Our ref: ECM 8464235  
Contact: Kathryn Sprang  
Telephone: (02) 4732 7834

27 November 2018

**Altis Warehouse and Logistics Hub at 585-649 Mamre Road, Orchard Hills  
(SSD 7173 MOD 5) - Modification Application**

STORMWATER CATCHMENT PLAN
SCALE 1:1000

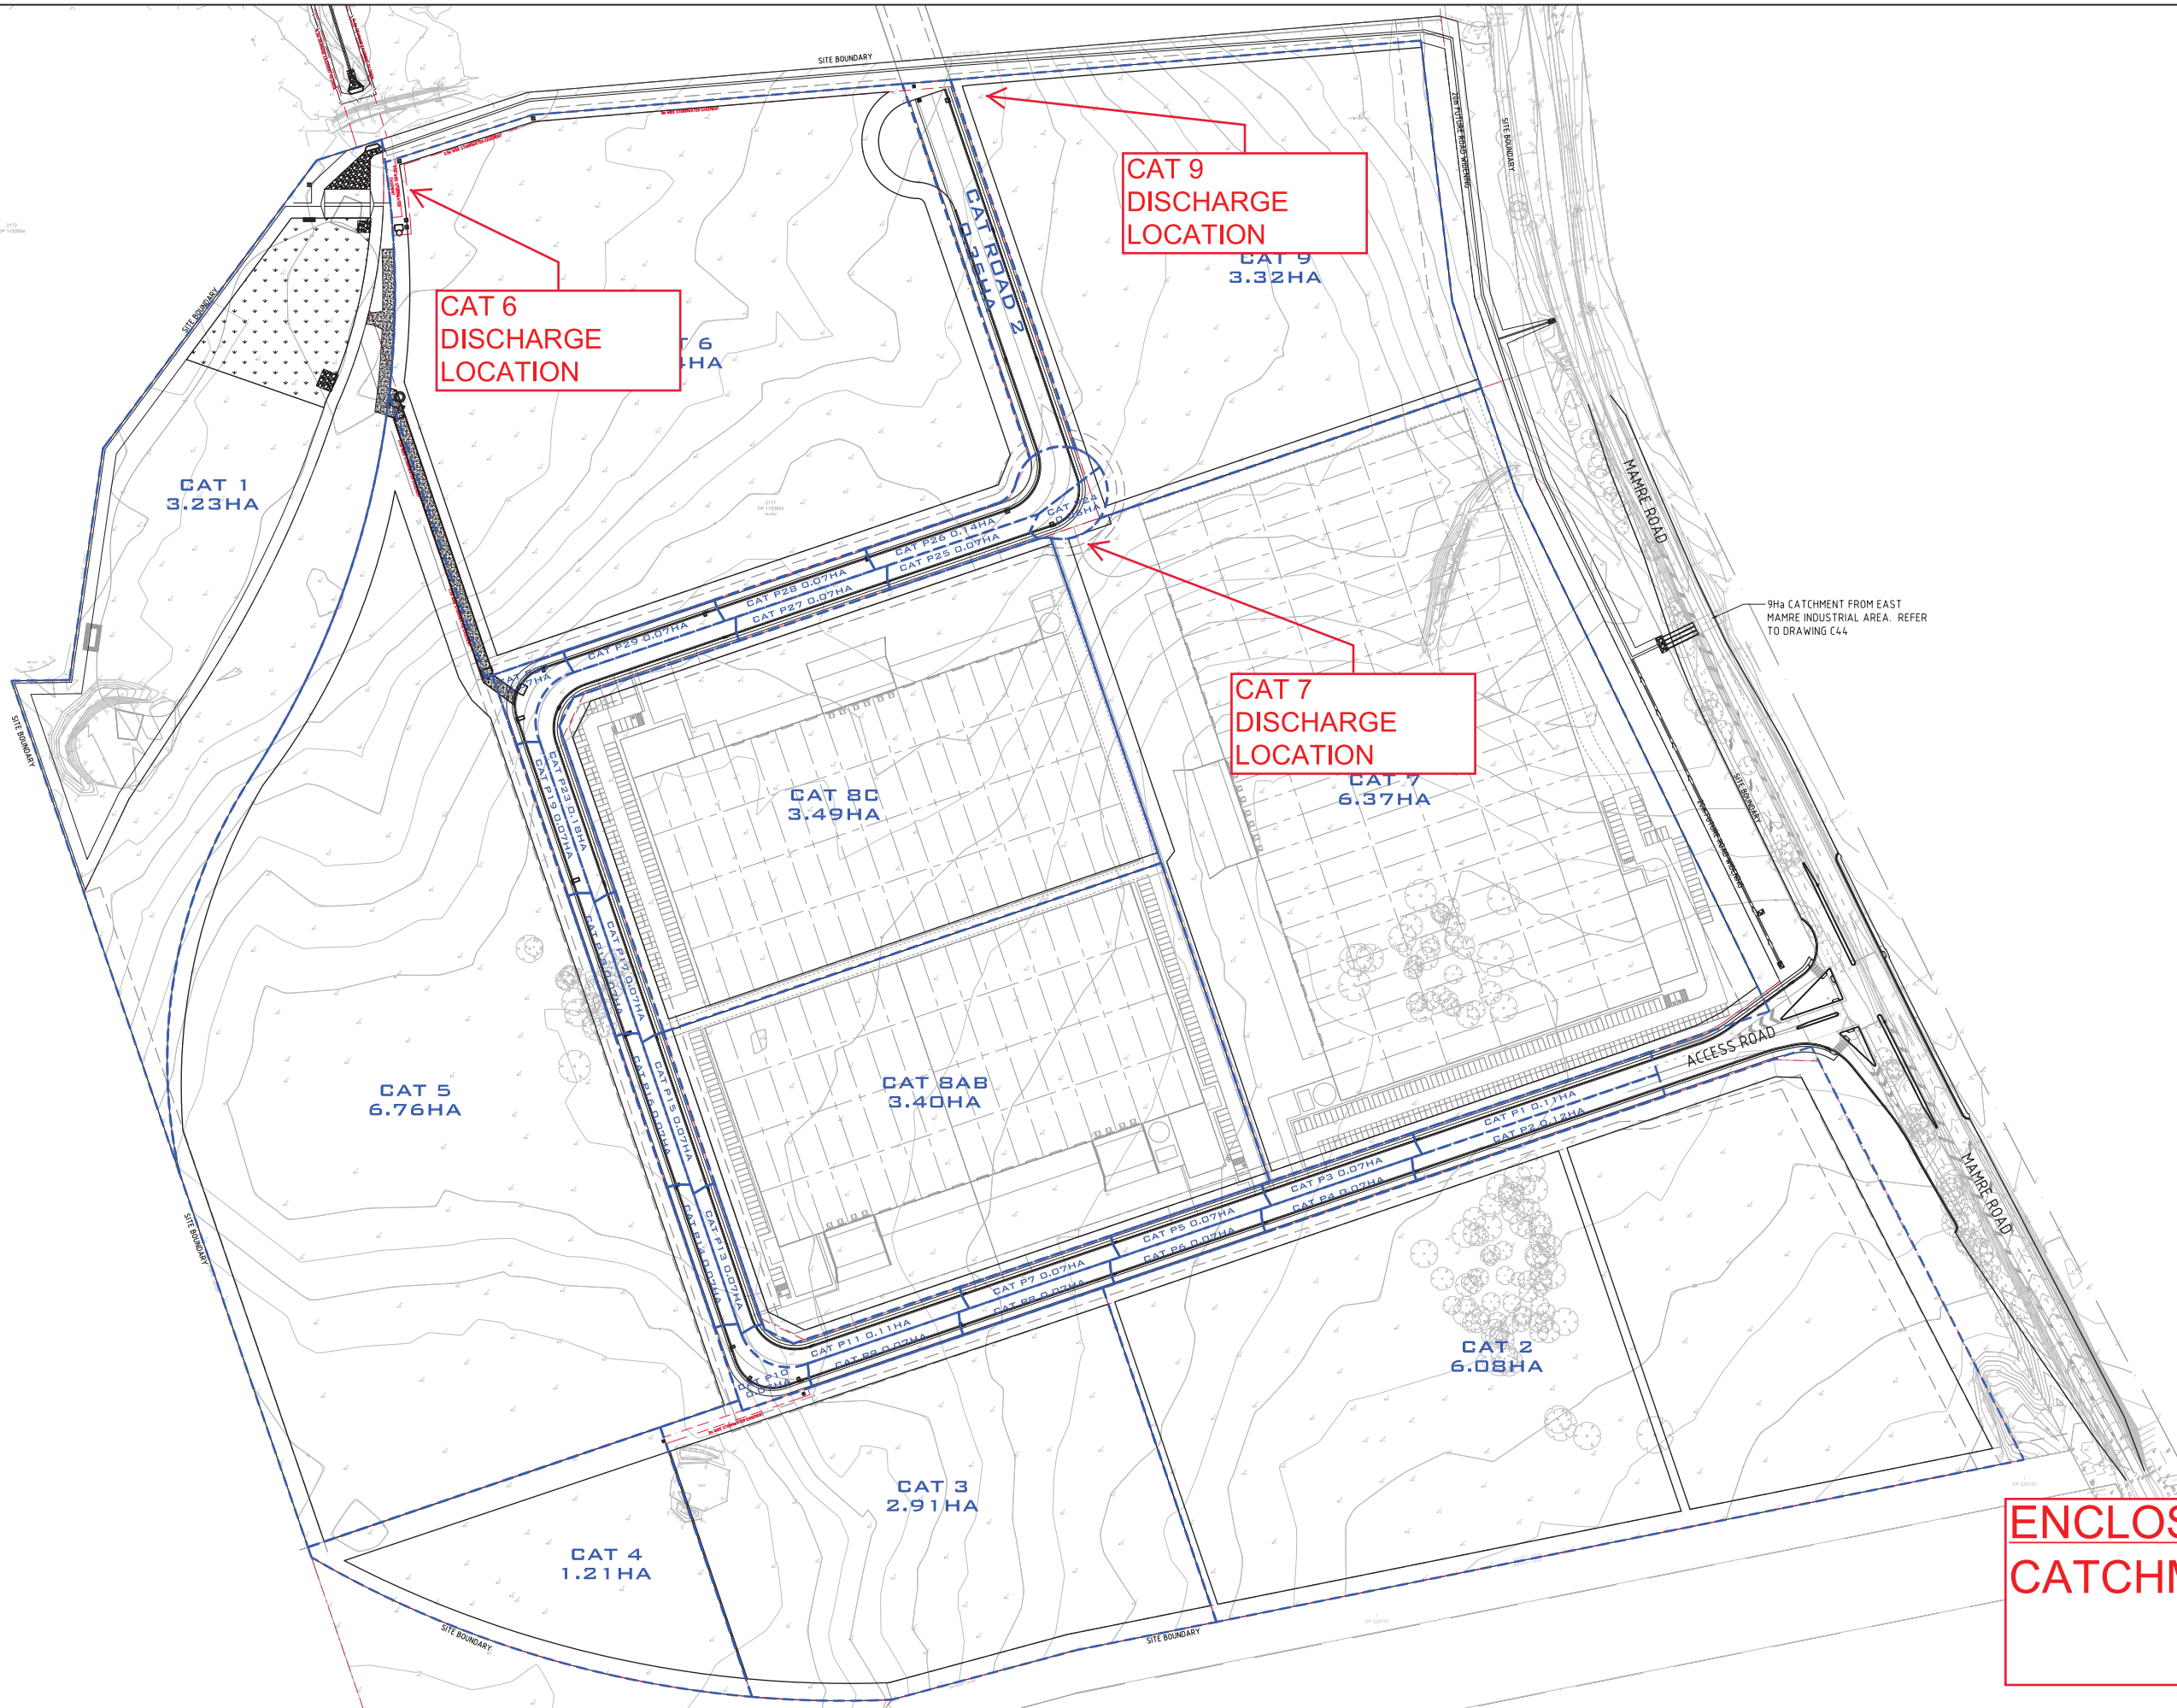
The proposed Civil & Stormwater Plans as submitted are not civil drawings and appear to be a copy of subdivision plan with hand written drainage notes.

A revised civil design drawing with level notations and associated contours is required which details the proposed drainage measures and any earthworks necessary to achieve this drainage scheme.

This also includes the location and width requirements for the identified easement over proposed Lot 10 benefiting Lot 11 and whether the proposal includes the installation of a underground drainage pipe.

The plan(s) should also detail how the amended lot arrangement and indicated catchment splits (as evident within Proposed Lot 10) can be accommodated without additional or revised earthworks to achieve the drainage design as approved.

Enclosure 2a - Proposed Subdivision -

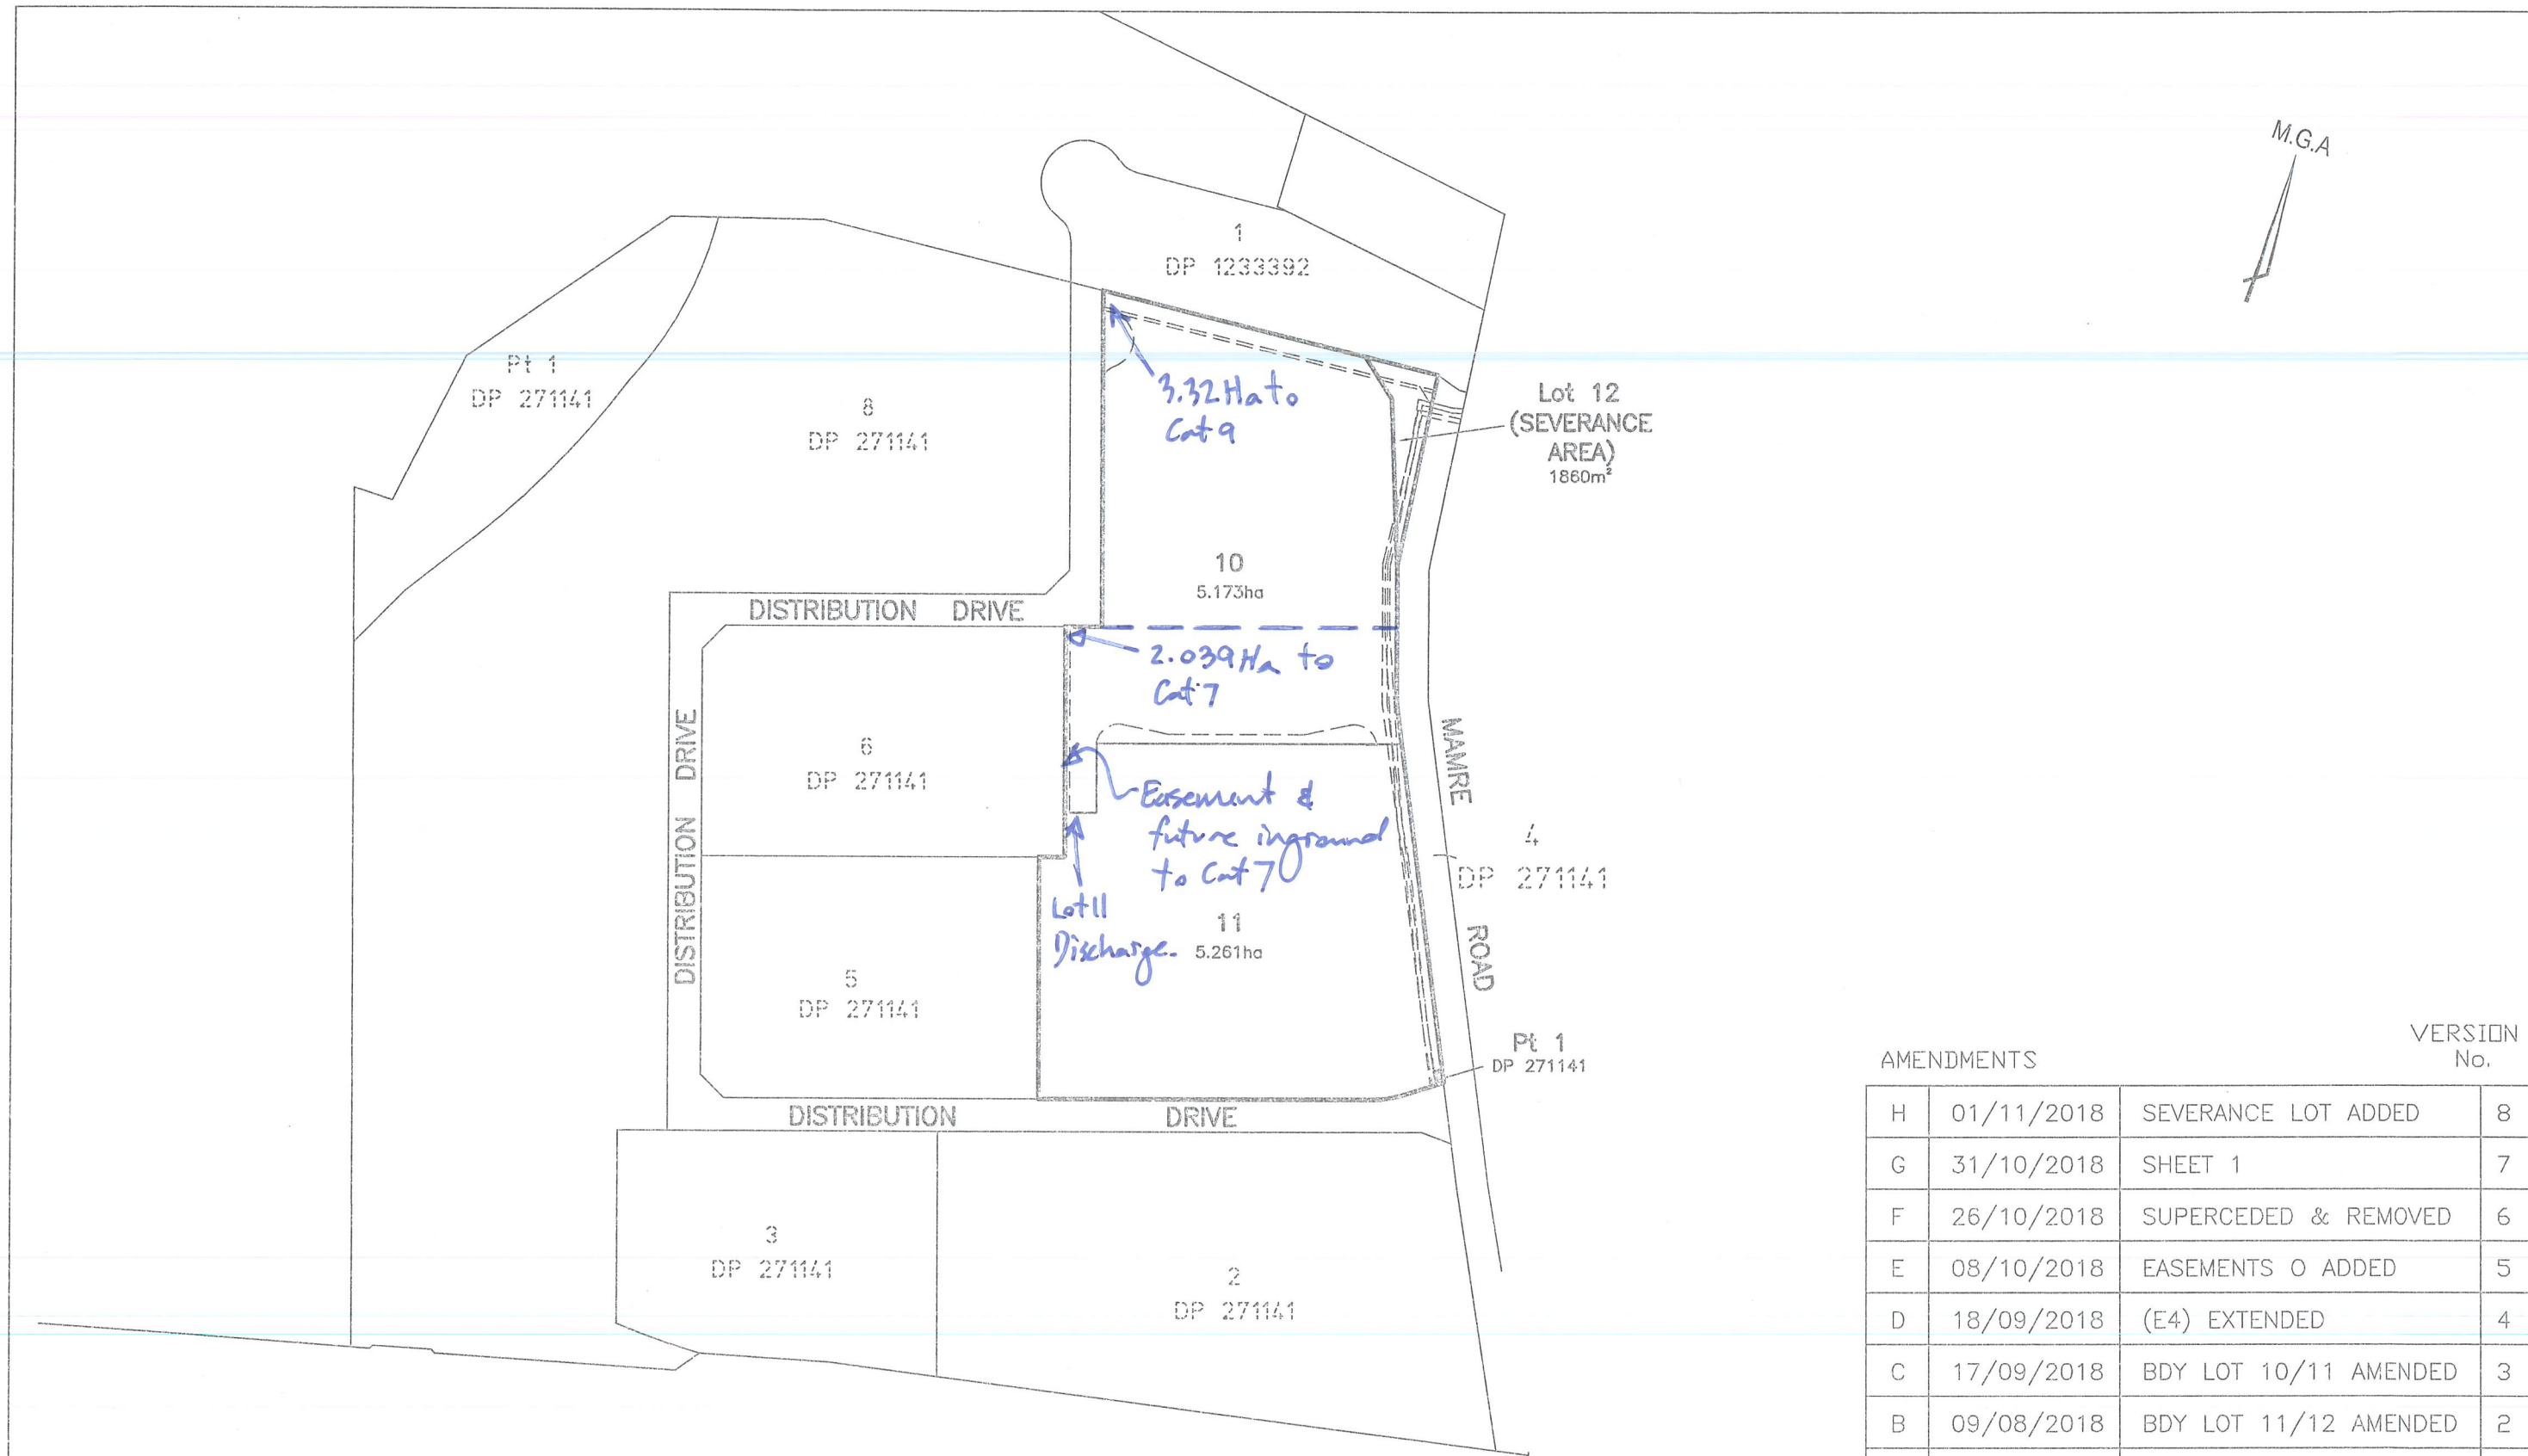
The rationale for the creation of irregular boundary lines between proposed Lot 10 and Lot 11 and the creation of Lot 12 is not clear and requires clarification to address orderly development principles. The following clarification is therefore sought to enable further consideration of the proposal:-

- The internal boundary arrangement of the approved subdivision plan (as per SSD 7173 MOD 2) seems more logical and provides for regular shaped lots. The boundaries of proposed Lot 10 and 11 subject of this

application are now irregularly shaped and it is unclear as to the benefit/reasoning behind the proposed subdivision pattern as revised. While the statement of environmental effects references separate development applications (SSD9429) for built form works, it is not clear how this separate application dictates or requires the irregular boundary conditions proposed as part of this modification application.
